From: [Kathryn Podobnik](#)
To: [Jamey Ayling](#)
Cc: [CDS User](#); [Michael Podobnik](#)
Subject: CU-23-00003- Podobnik -Roadways & Property Values
Date: Thursday, October 19, 2023 12:51:23 AM

I have a few final comments/considerations regarding CU-23-00003.

FOWLER CREEK GUEST RANCH
EXHIBIT 12
EMERGENCY INGRESS AND EGRESS PLAN

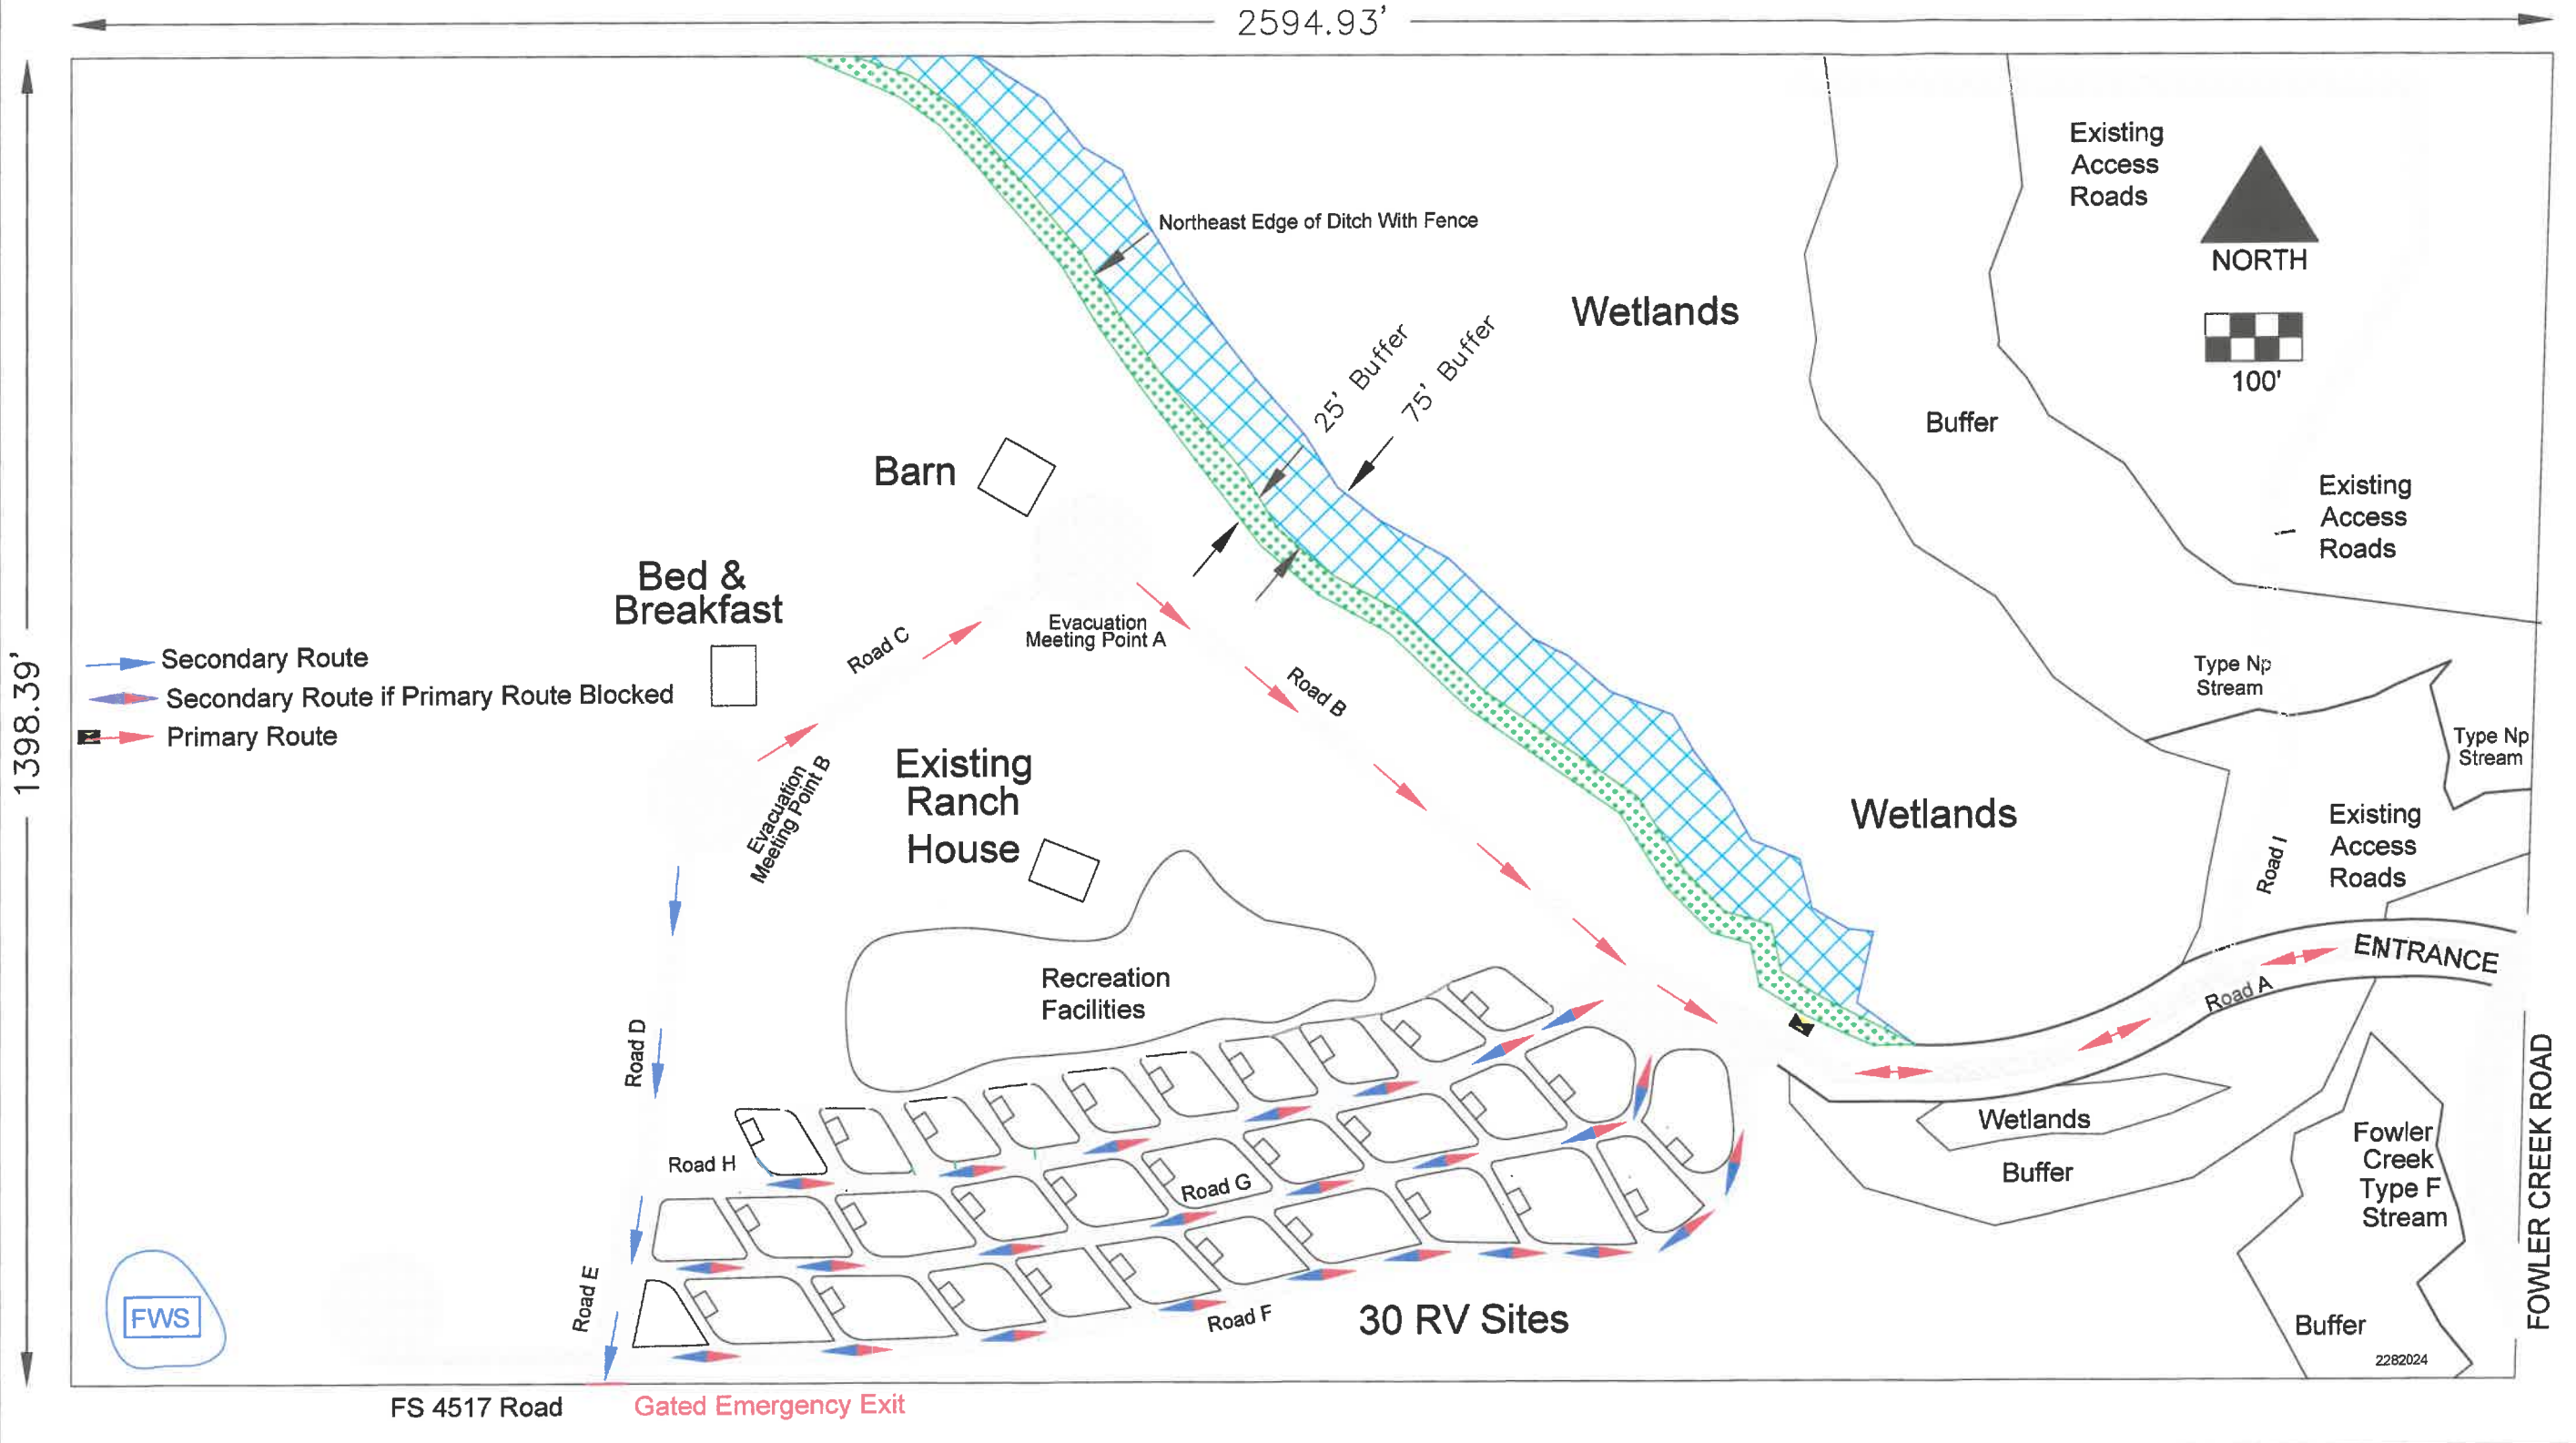
One of the proposed egress points, marked "exit" on the site plan, is a residential easement that connects to Forest Service Road 4517. The Forest Service maintenance level 2 is defined in the FSH 7709.59, sec 62.32 as:

At this maintenance level, Recreational Vehicles most certainly are not appropriate. Their clearance is too low, and the road has inappropriate width, site lines, grading, and clearance. It should be noted that currently, the **residents of the Granite Creek community** pay to maintain this road beyond the FS maintenance provided. This includes paying for professional chip sealing, snow plowing, drainage clearance, and brush/tree removal. Should

EXHIBIT 16 - SITE PLAN - FOWLER CREEK GUEST RANCH

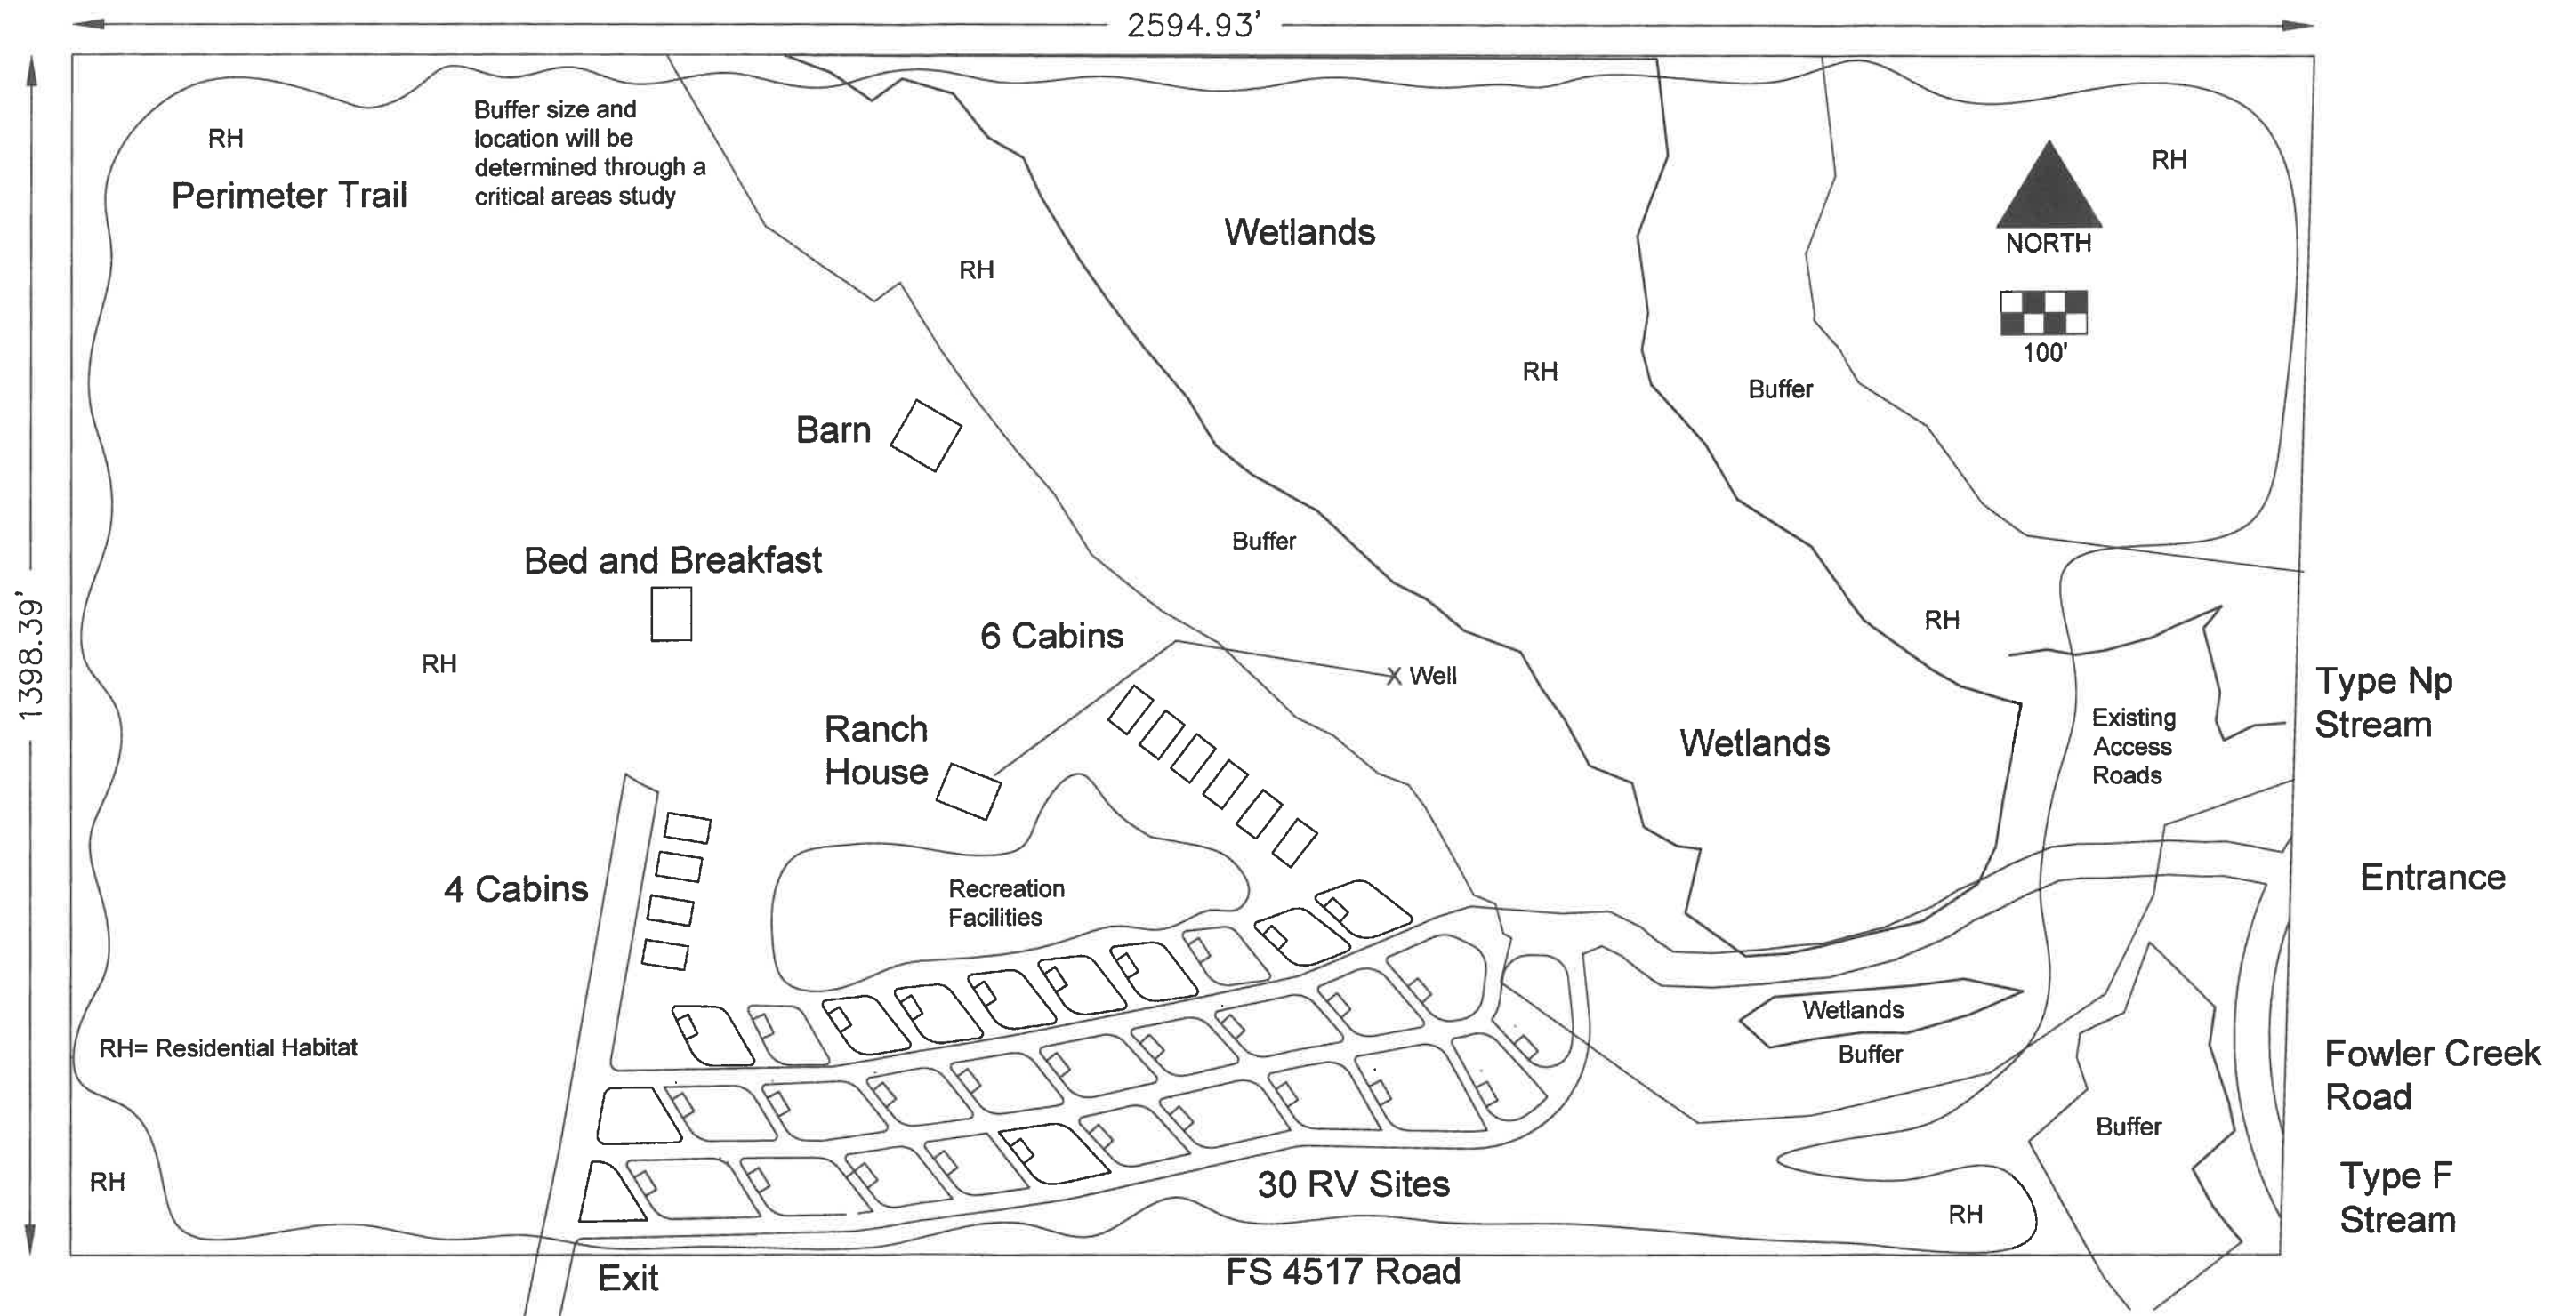
The site plan even utilizes an existing residential easement, of one of the Granite Creek properties, for substantial commercial activities. The bulk of the development is localized in the SW corner, directly next to surrounding homes.
